From: [Holly Duncan](#)
To: [Jeff Watson](#)
Subject: RE: BL-10-00032 Helley
Date: Wednesday, July 28, 2010 11:27:29 AM

From: Jeff Watson
Sent: Thursday, July 22, 2010 11:38 AM
To: Christina Wollman; Brenda Larsen; Jan Ollivier; Holly Duncan
Subject: BL-10-00032 Helley

[BL-10-00032 Helley](#)

EXHIBIT A

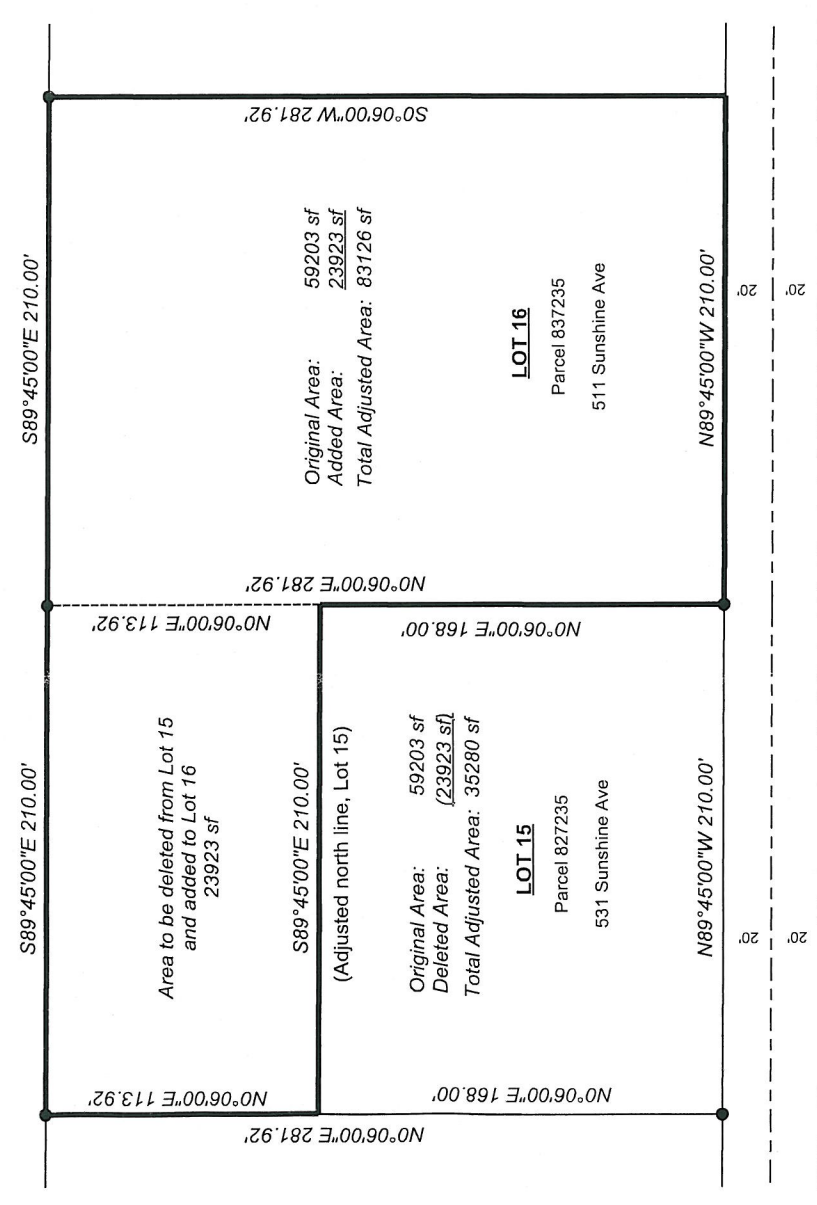
There are existing wells and on site sewage systems on both of these lots. The new lines must be the required 50 feet away and the locations of the septic systems need to be taken into consideration.
